Greatford Parish Council Deadline 9 submission.

Comments upon the proposed 60 year time frame of the Mallard Pass solar farm development, the and effects at decommissioning upon future ALC grading and soil quality.

Plate 7: Typical PV Array

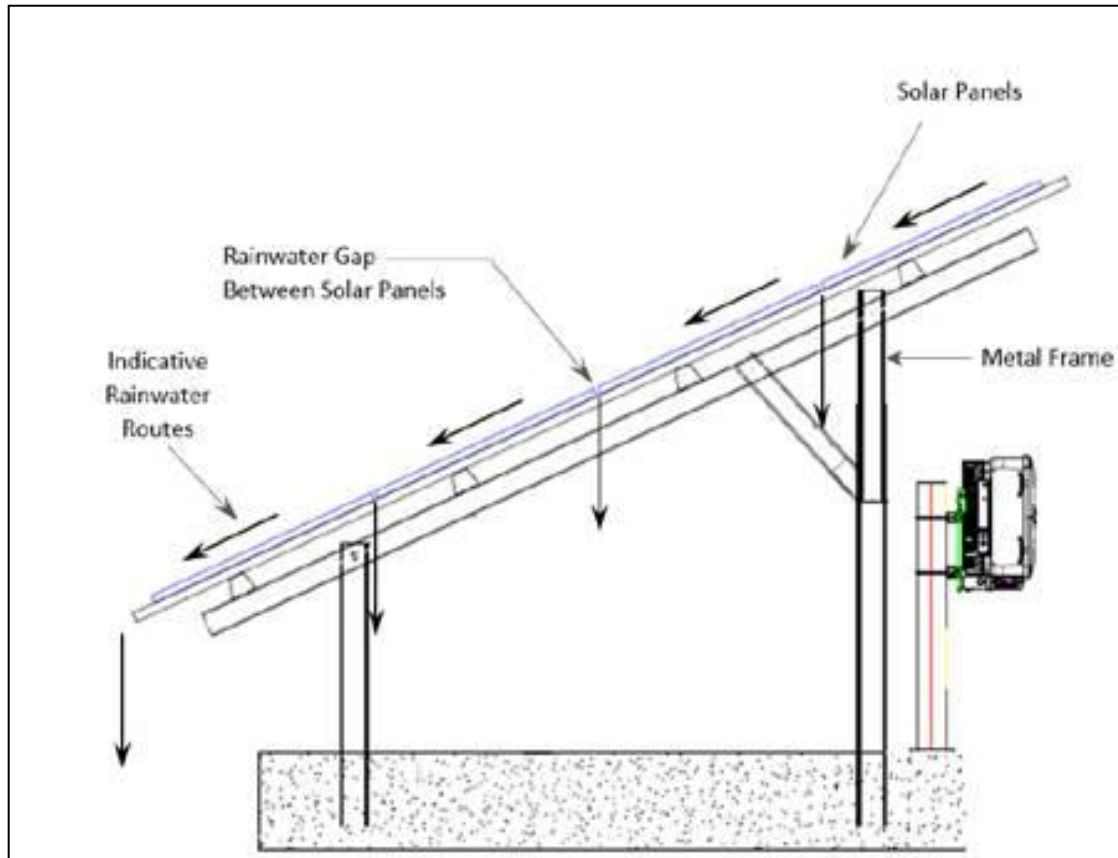
"Land between and underneath the PV panels is often grazed by sheep and where there are high numbers of sheep a solid compaction layer 2 cm to 6 cm over a wide area may result (Defra, 2021). There is likely to be some instances of run-off from the solar panels, which could result in the

compaction of soils at the base of the panels (Choi et al,2020). Over time rivulets can form along the trailing edge of the panel with potential risk of soil erosion creating rills and gullies across the site.”

Until vegetation is established, the rainwater falling onto the panels will erode the unprotected soil beneath the panels and carry it as surface runoff into the ditches, and ultimately the West Glen river that drains the proposed development site. This will increase the risk siltation and flash flooding downstream of the proposed development.

Plate 9: Establishing Grass Mix Under PV Drip Line³¹³²

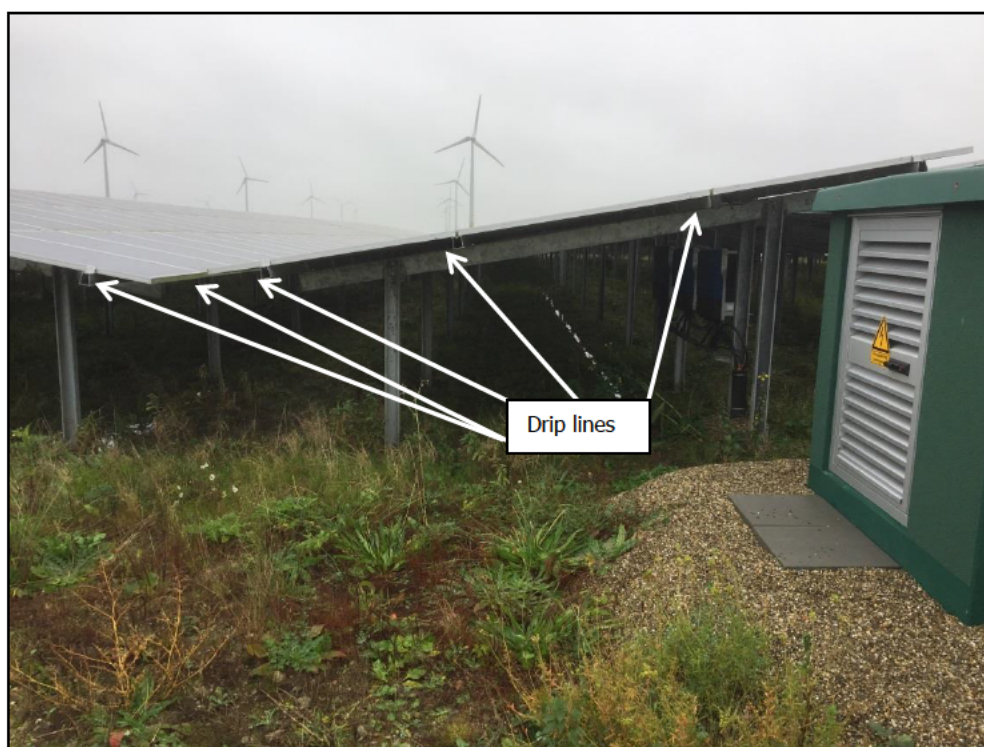
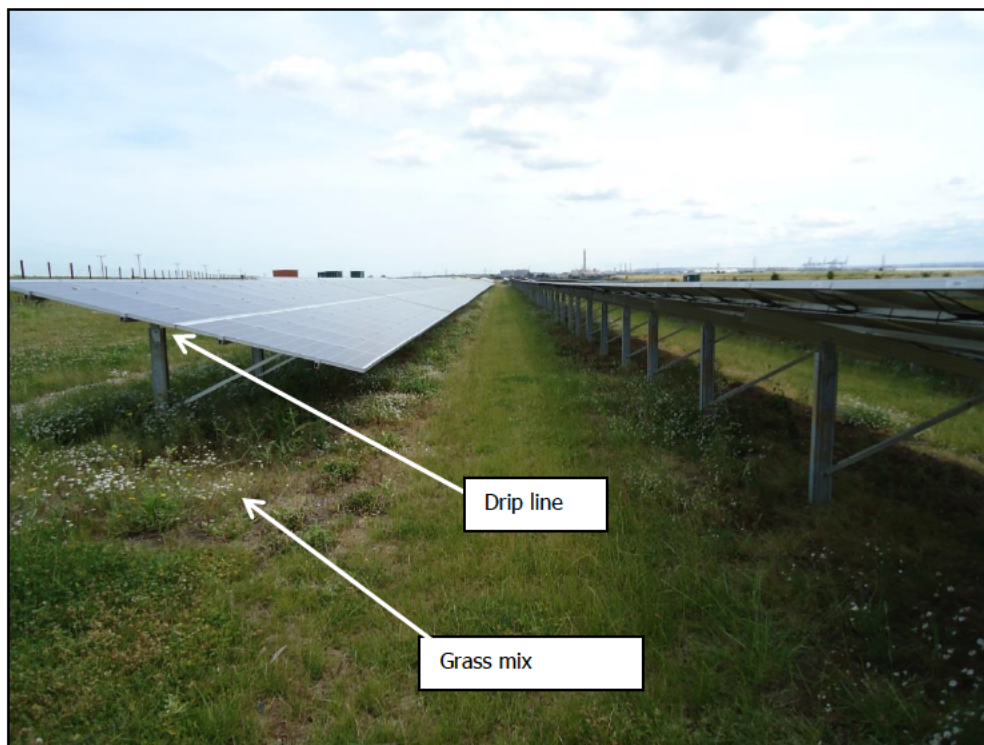
The above image shows a situation where foliage has failed to develop underneath the solar array. This is highly likely to be the situation where grassland establishment takes place after construction (as indicated in the GEMP). If this is how poorly established vegetation looks after 12 month then in subsequent years it will be very could be much worse.

This confirms our concerns that plant & soil processes will be significantly impeded beneath the proposed solar panel arrays, and further underlines how the proposed practice of sowing grass underneath panels just before, at, or post construction will not result in a vegetative cover capable of performing the functions required as it will not grow. This is probably what the scenario in the figure 6 image above.

Again this underlines how critical it is to establish vegetation well before construction so as to avoid surface runoff and erosion.
